Submission No.			71		
Organisation Name or Name of Submitter			Dublin City Council		
Item No.	Section Ref.	Page No.	Observation Statement	TII Response	
Written Submission from Dublin City Council's Chief Executive to An Bord Pleanála in relation to the National Transport Application for the Railway (MetroLink - Estuary to Charlemont via Dublin Airport) Order [2022]					
1	2.4.1 Planning Policy	22	While the Proposed Scheme is supported, it is important that the proposal adequately addresses conservation impacts along the route as well as the potential to improve green infrastructure and pedestrian and cycle connectivity and permeability.	<p>TII have included for the conservation mitigation of impacts throughout the Project and have appointed a Project Conservation Architect (PCA) to oversee the implementation of mitigation measures relative to the Built and Cultural (inclusive of Industrial) Heritage during the lifetime of the Project. The responsibilities of the PCA and proposed mitigation measures are outlined in the Construction Environmental Management Plan in EIAR Volume 5, Appendix 5.1 and MetroLink Cultural Heritage Strategy Rev.02.</p> <p>MetroLink will provide significant b

Client	TII NTA	Project	METROLINK	Drawing Title	METROLINK - STRUCTURES COLLINS AVENUE STATION PROPOSED STREET LEVEL DESIGN	Drawing Status	S0
Consultant	JACOBS IDOM	Drawing N°	ML1-JAI-SRD-ROUT_XX-DR-Y-02045	Plan Drawing N°	ML-ST 304 E-F1	Sheet 1 of 6	
		Scales Original Size A1	1:250

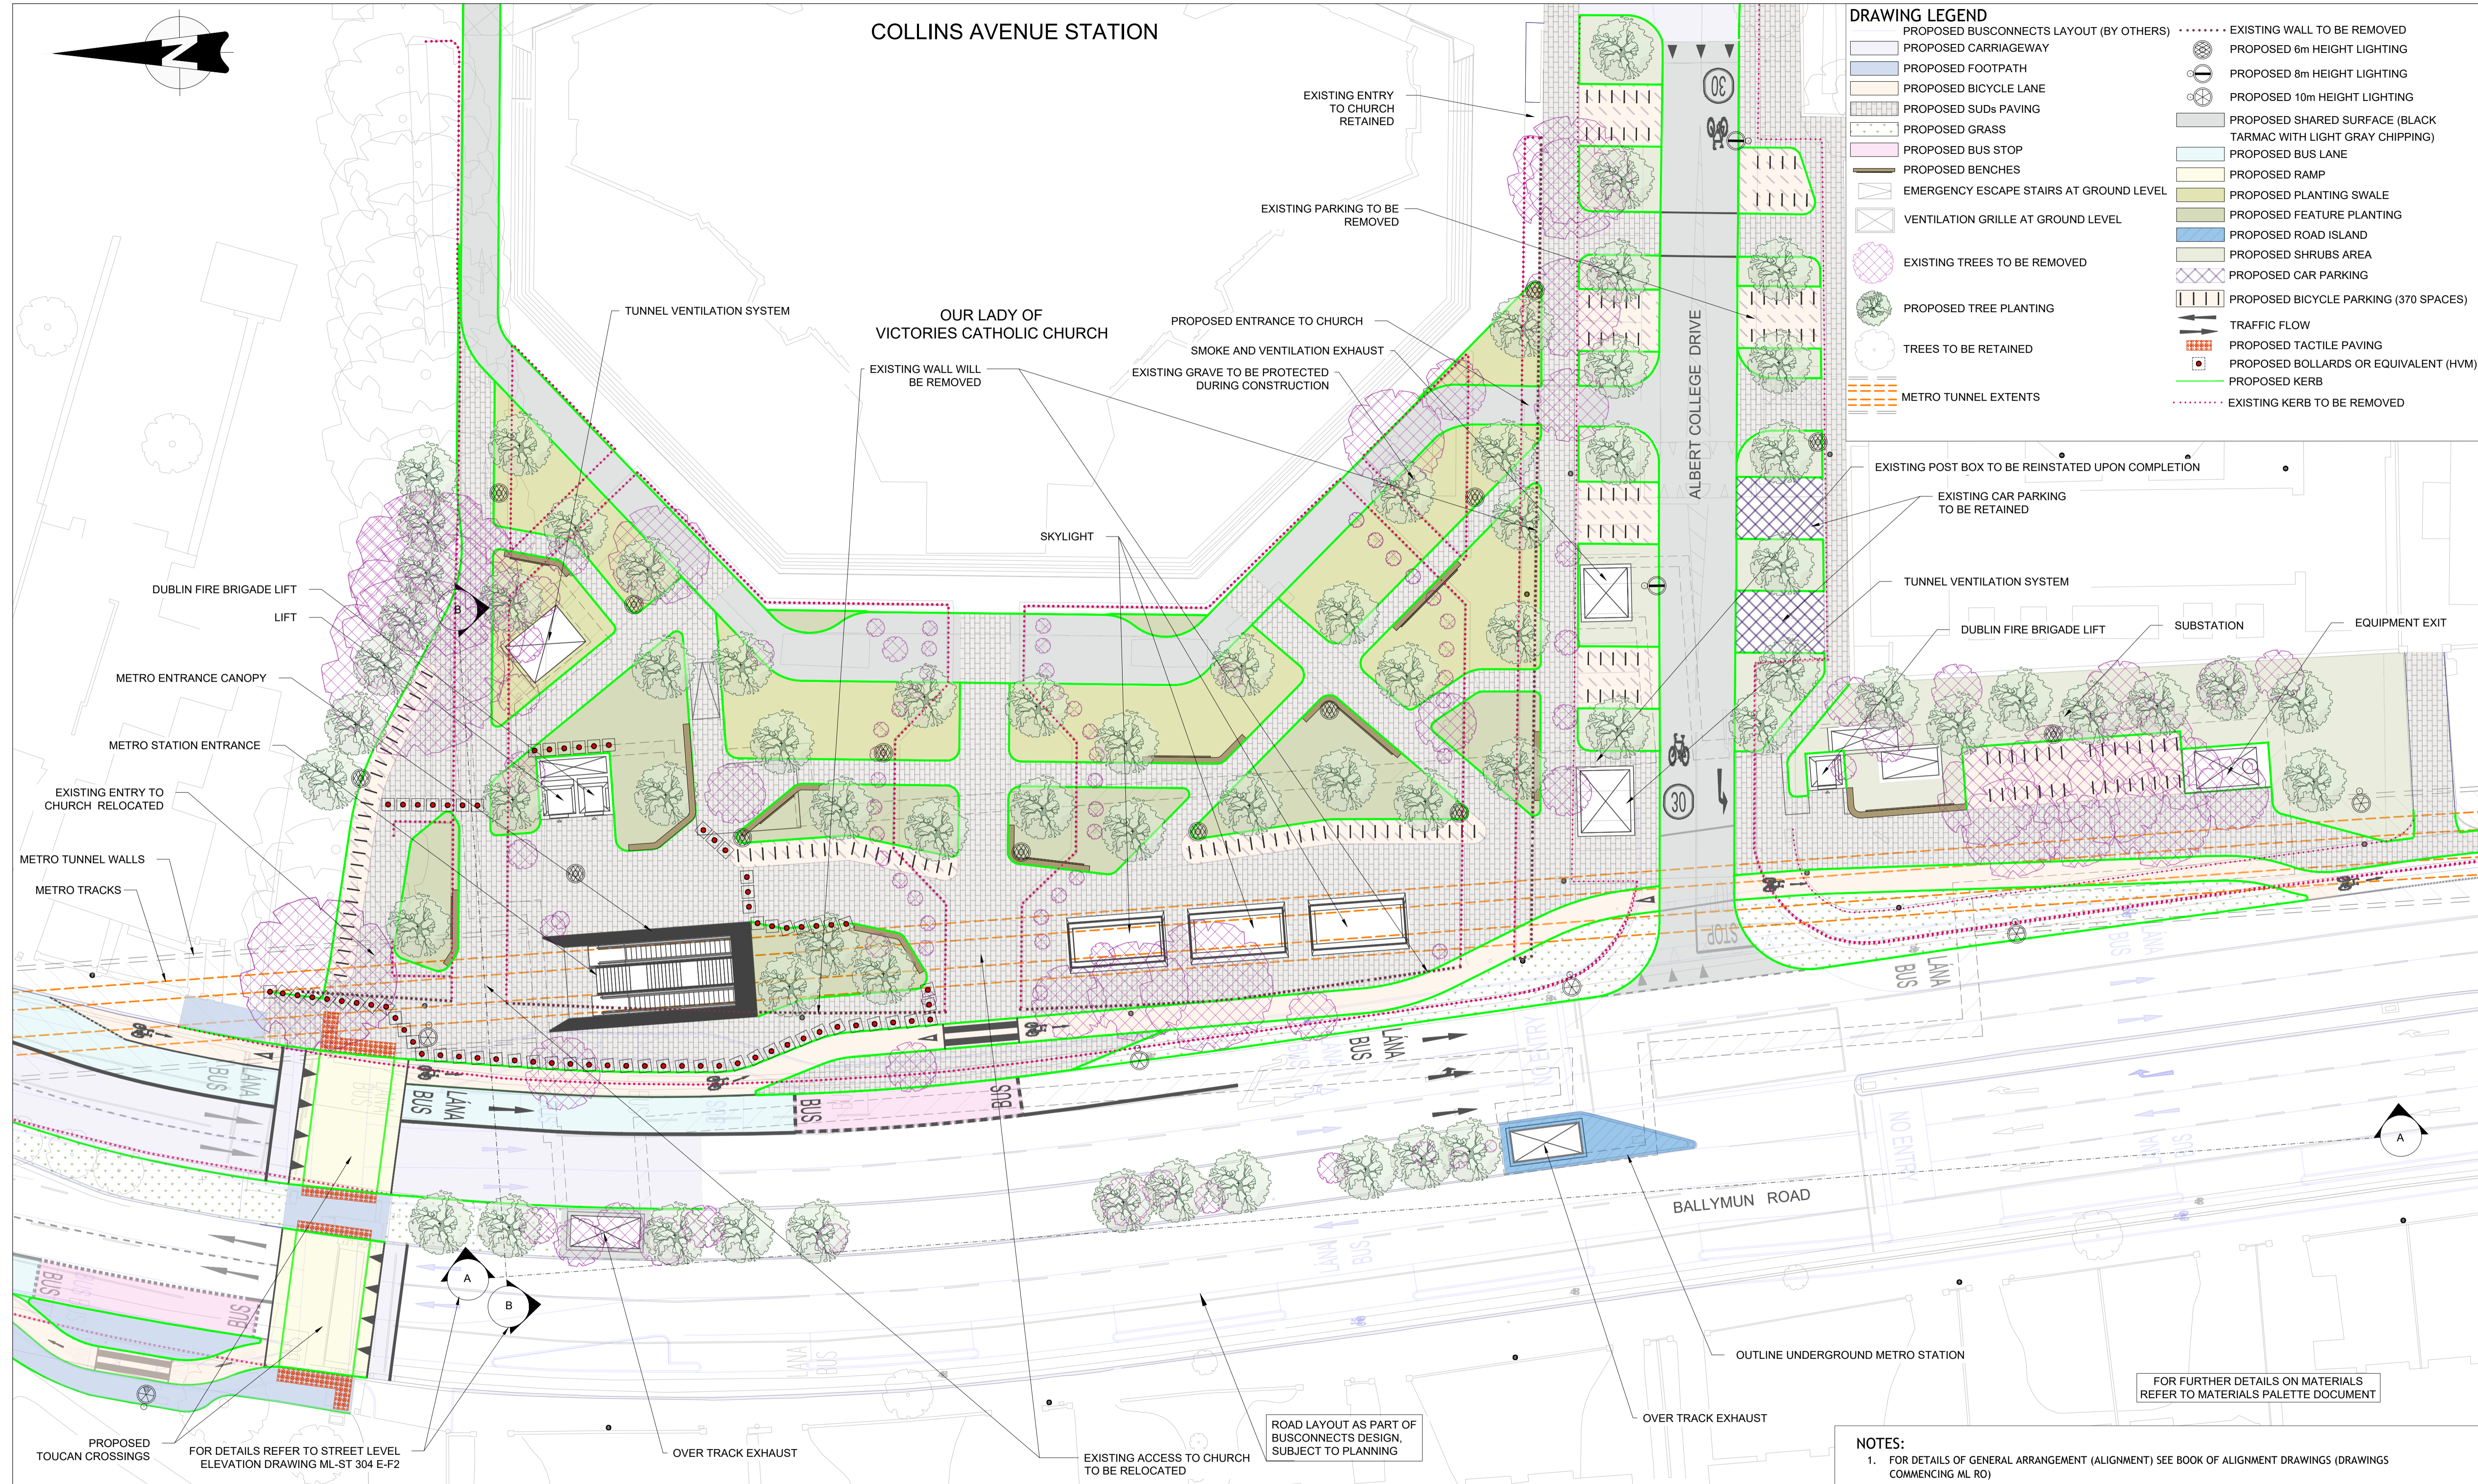
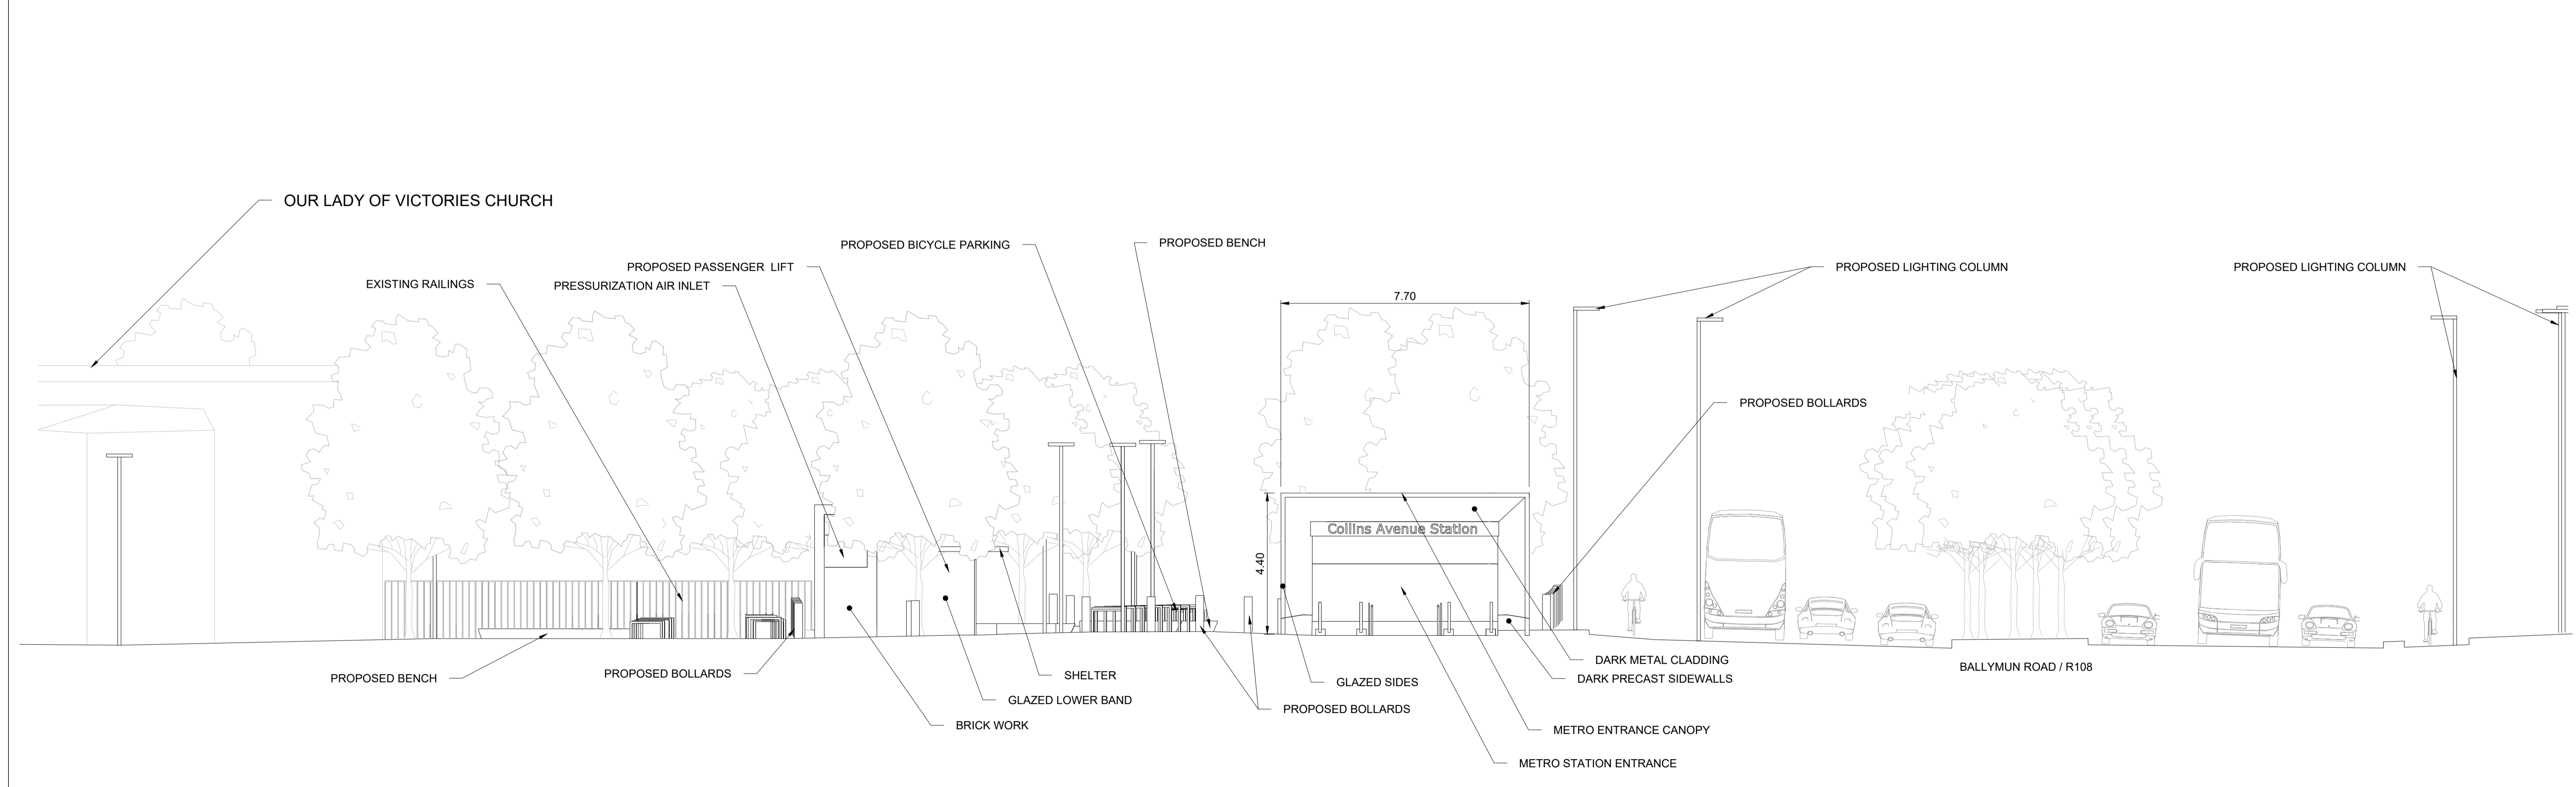
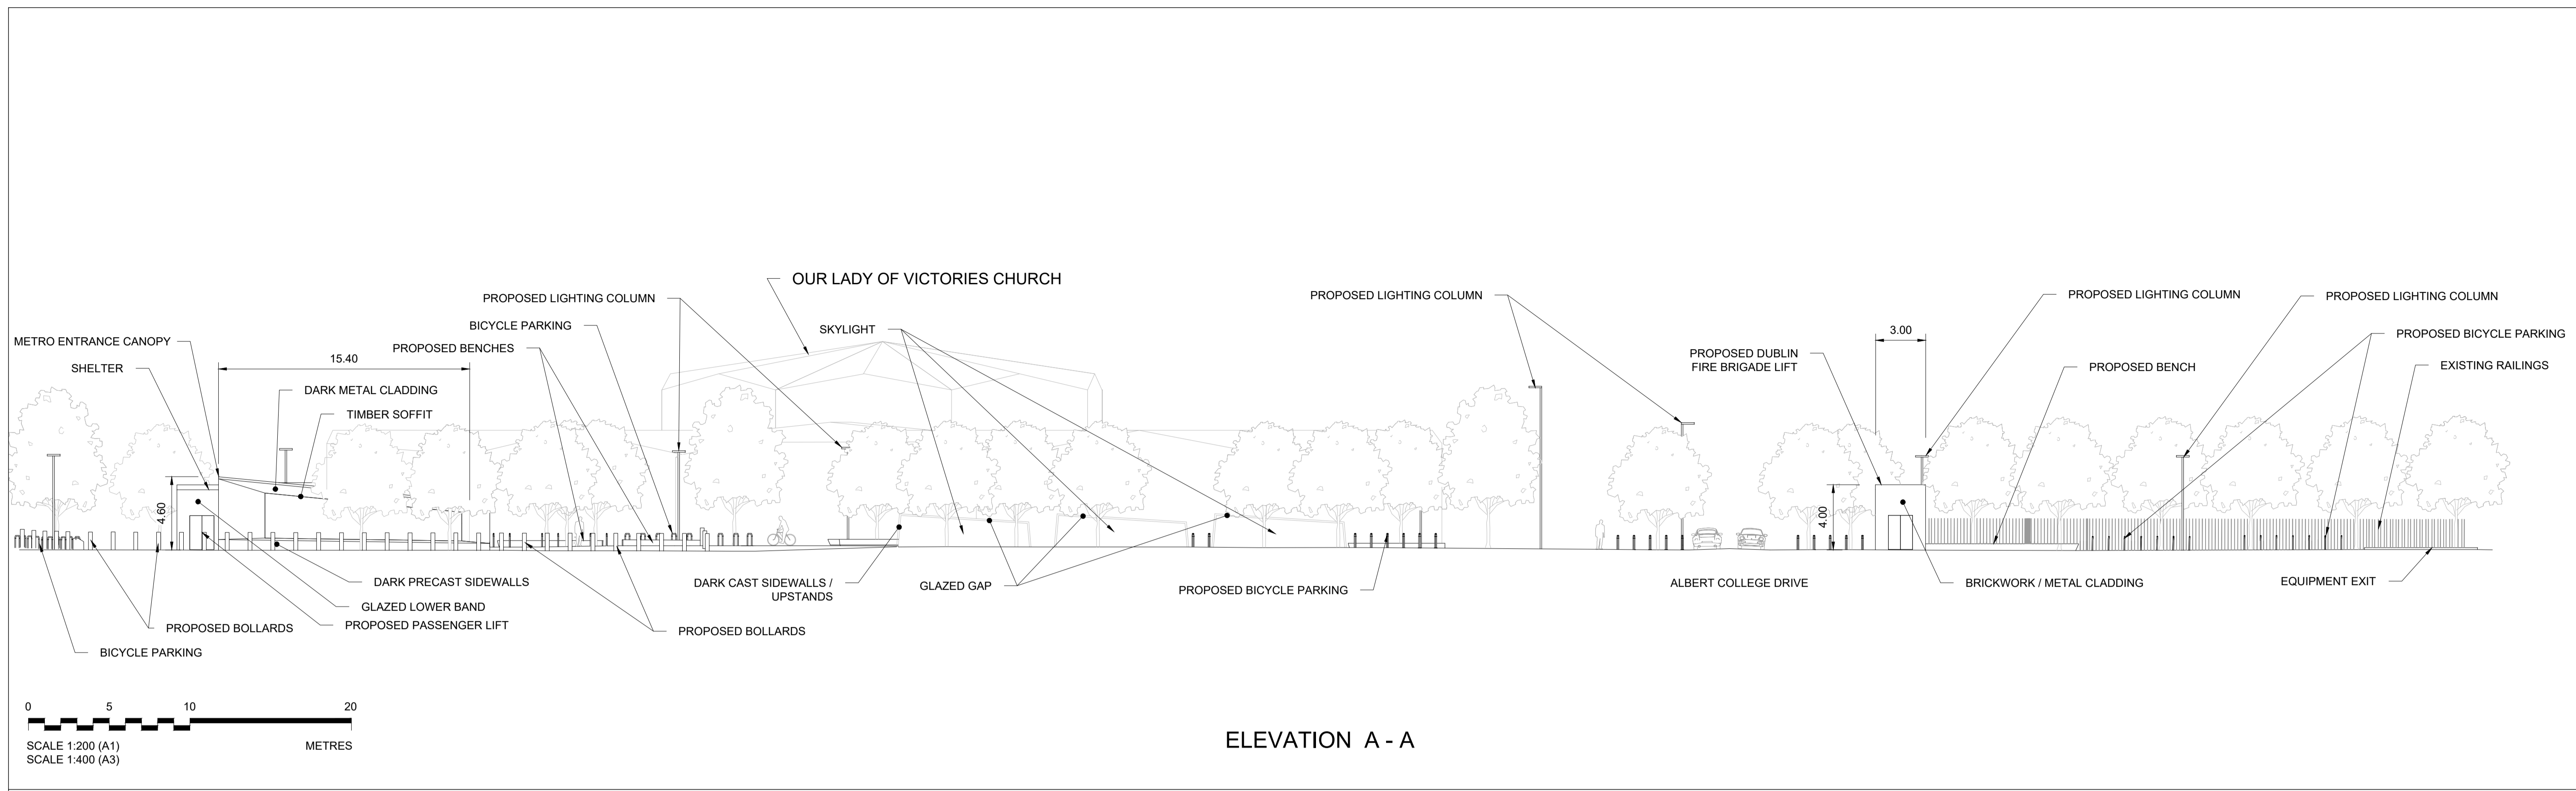
12	Conservation Section - summary of report - Collins Ave	27	The proposed works will give rise to the loss of trees which is most regrettable and should be mitigated by replanting/landscaping at all station locations where relevant.	Please refer to response (10) above.	
13	Conservation Section - summary of report - Collins Ave	27	Introduction of the new structures including the Metro Entrance Canopy, ventilation shafts, Fireman’s Lift and other features will interfere with the present harmonious symmetrical setting of the principal elevation of the Church (Refer to Photomontage WM 15.2, 15.2).	As outlined in EIAR Chapter 27, The Landscape, section 27.5.4.16, the design of the proposed Collins Avenue Station includes public realm improvements where possible. It is noted that while the entrance canopy, row of three surface mounted skylights, lifts vents and emergency exits will alter the landscape in front of the Church, the Station design incorporates a broad section of new attractive public realm and garden to the front of the Church. This features high quality paving, seating, bike parking, and garden tree planting with swale planting and ornamental ground cover planting to create a green and welcoming public realm. While not a direct reproduction, care has been taken to reference the orthogonal shape of the church in the proposed footpath design. TII consider that the improvement to the overall appearance of the landscape and public realm associated with the front of the church will also assist with the integration of the Station features.

14	Conservation Section - summary of report - Collins Ave	27	The location of the various structures associated with the Station Box is driven by standard and not bespoke relationships between the different elements. The magnitude of the impact will be high and the potential effect will be significant.	TII do not concur with this observation. The location of the various structures that are associated with each Station have been particularised at each location taking account of the existing urban realm and the above ground features have been consolidated and integrated where possible to create a legible and clutter free environment.- The concept design aims to balance church and station requirements. The proposals do impact the existing environment, however TII believe that the effect is to improve the quality of public realm, addressing both the important church architecture and public thoroughfare to the front of the church, through the careful design of the soft and hard landscaping, as well as the considered integration of the station elements. Please also refer to response (13) above.

40	Environment & Transportation Department (E&T)- summary of report: Traffic Division - Collins Avenue	30	The rationale for providing new parking spaces on the existing carriageway opposite the MetroLink station on the Ballymun road is not clear to DCC and it is our view that these spaces should be removed or their rationale clearly explained	The new parking spaces referred to, on the existing carriageway opposite the MetroLink station on the Ballymun road are to be provided by BusConnects project and are not included in MetroLink scope of works.
